DELEGATED ITEM FILE REPORT - APPROVAL

3/2012/0669/P

Full application for the proposed erection of an industrial unit and alterations to parking provision on land at Lincoln Way, Clitheroe

Notes:

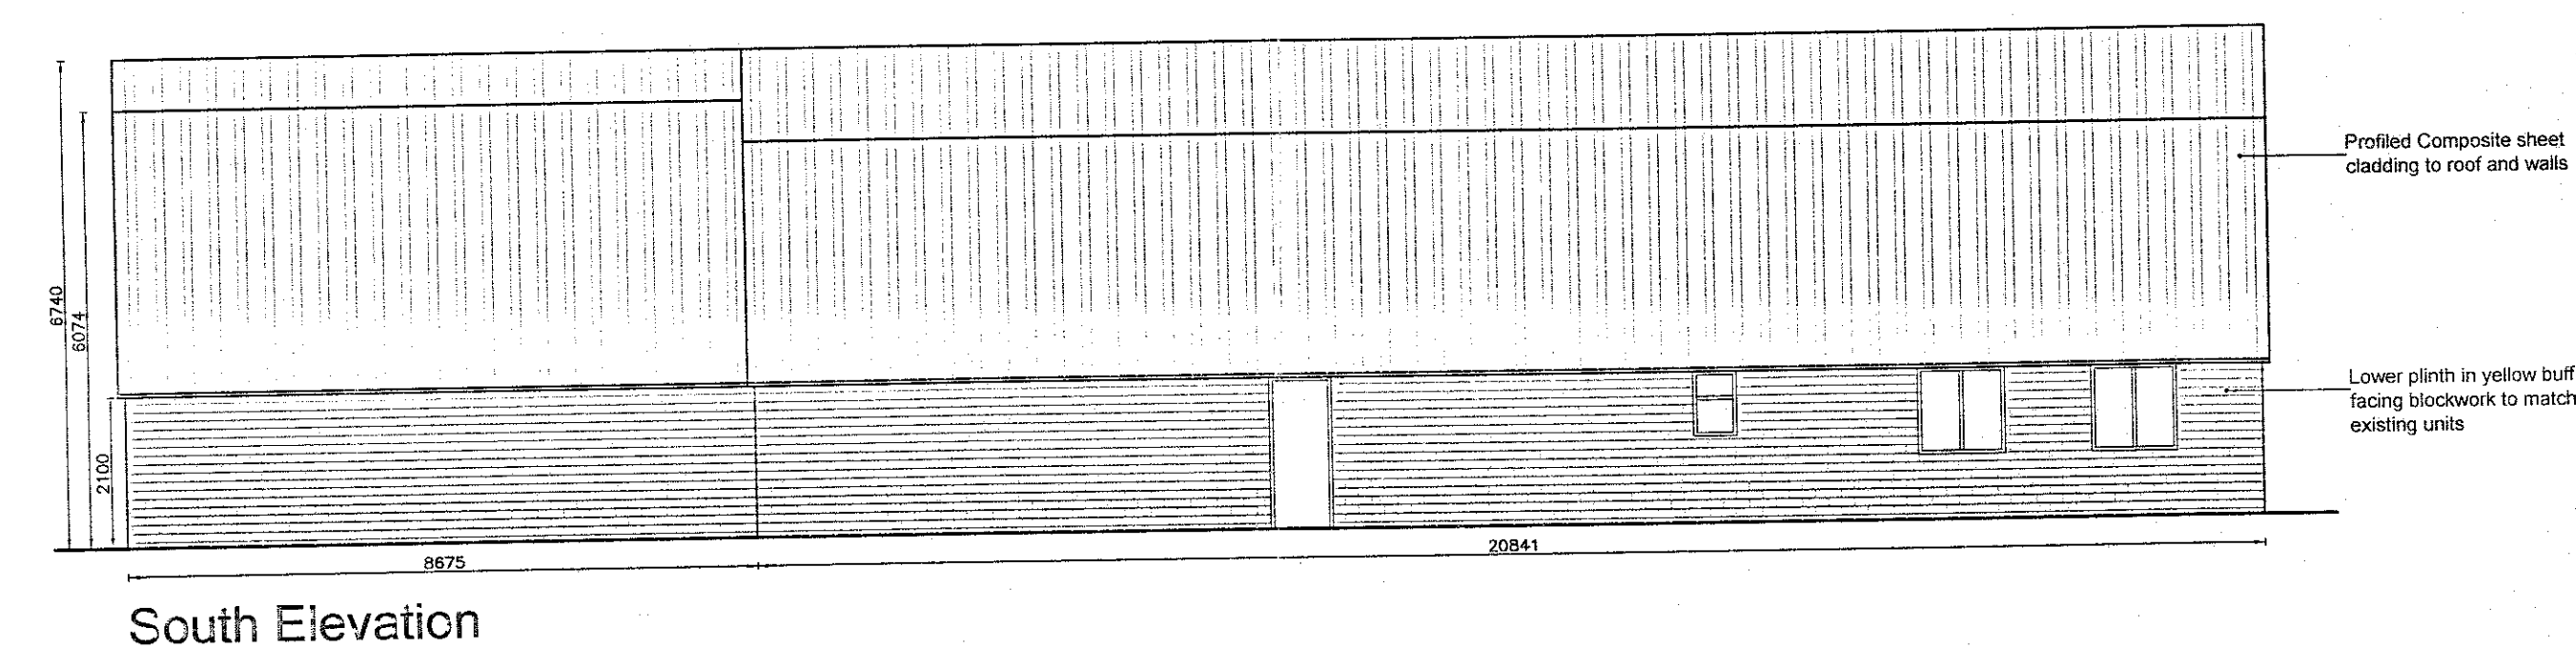
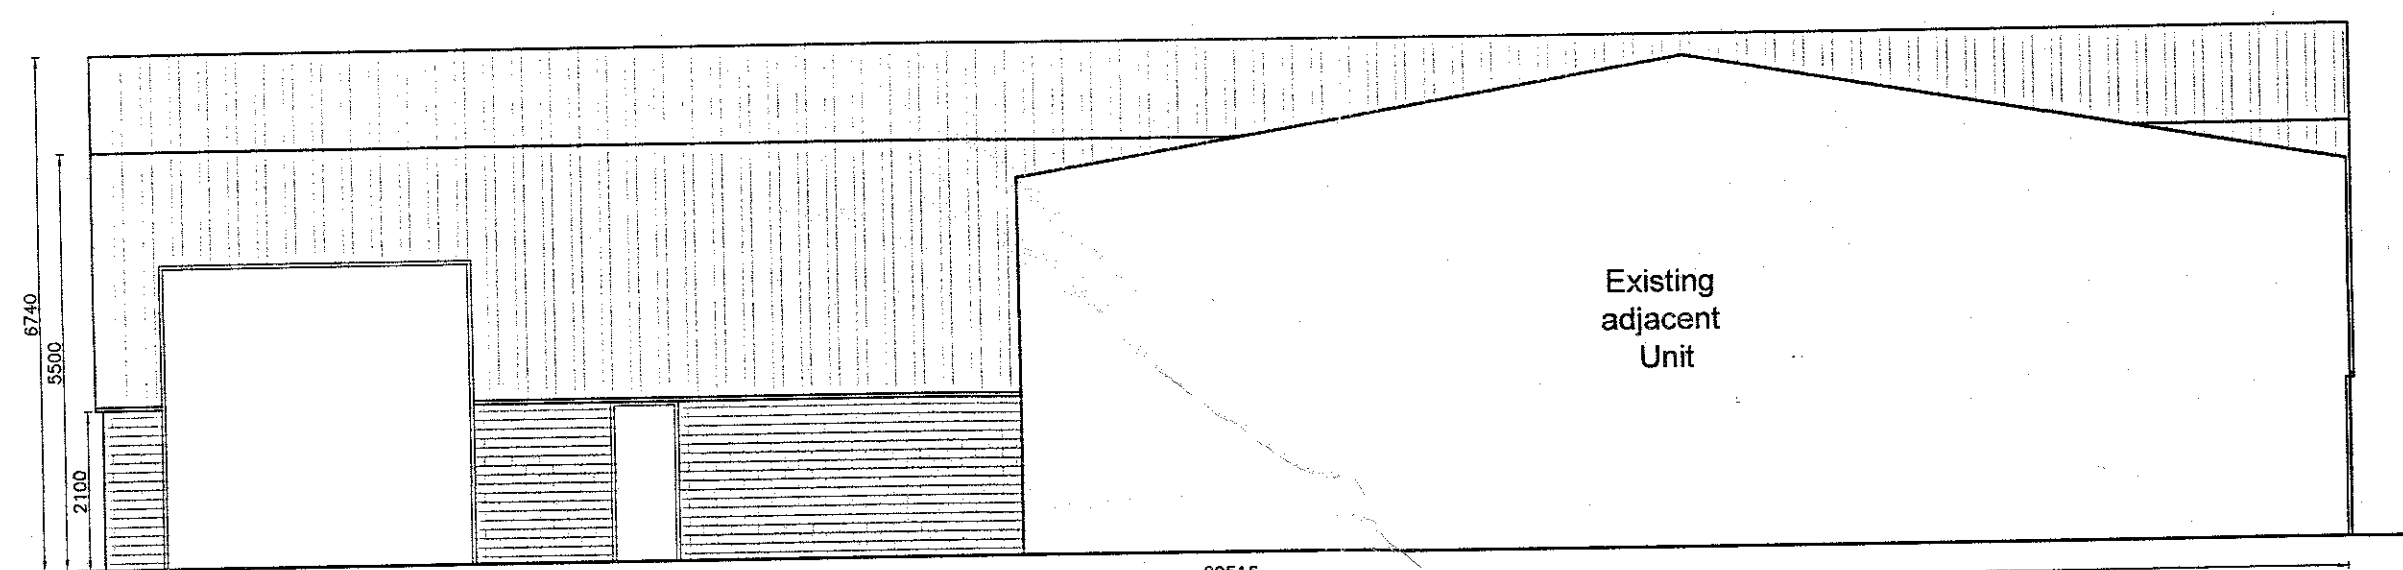
Environment Agency – Originally objected to the application for the reason that the proposed building would be within 8m of the top of the bank of Mearley Brook which is designated a main river. The proposal would therefore be contrary to Land Drainage By-laws. The Agency commented that it would be unlikely to give consent for the development because it would unduly restrict essential maintenance and emergency access to the main river watercourse; and that the permanent retention of a continuous unobstructed area is an essential requirement for the future maintenance and improvement works to this river. The Agency did advise that their objection could be overcome by a revised scheme but that the building should still not significantly encroach within 8m of the top of the riverbank. They recommended that the applicant should contact the Environment Agency to discuss their access requirements and provide revised plans and drawings showing the top of the riverbank and detail how any revised scheme would incorporate their requirements.

By letter dated 10 October 2013, the Environment Agency confirmed their agreement to a 4m wide access strip as shown on the amended plan received 18 September 2013 and confirm that they therefore withdraw their objection to the proposed development. The Environment Agency, however, further explains that, under the terms of the Water Resources Act 1991 and the Land Drainage By-laws, the prior written consent of the Agency is required for any proposed works or structures in, under, or within 8m of the top of the bank of the main river Mearley Brook. Such an application for Flood Defence Consent has been submitted and has been approved.

As originally submitted, the footprint of the building measured 26.6m x 11.5m with a link to the existing building having a footprint of 16.5m x 0.9m, all in accordance with the previously approved scheme. The footprint of the building has been slightly reduced on an amended plan in order to satisfy the requirements of the Environment Agency. The building in the originally approved scheme had a mono-pitched roof but, in this current application, the building has a traditional ridged roof with an overall height of 6.8m and an eaves height of 5.5m. This is considered to represent an improvement in visual terms on the originally approved roof design.

Notwithstanding that the size and location of the building was the same as previously granted by the outline permission, the Environment Agency originally expressed an objection to the application. As stated above, however, through negotiations with the Environment Agency, the shape of the building has been amended in order to provide a clearance to the bank top of Mearley Brook that is now to the satisfaction of the Environment Agency. That initial objection to the proposed development is therefore now overcome.
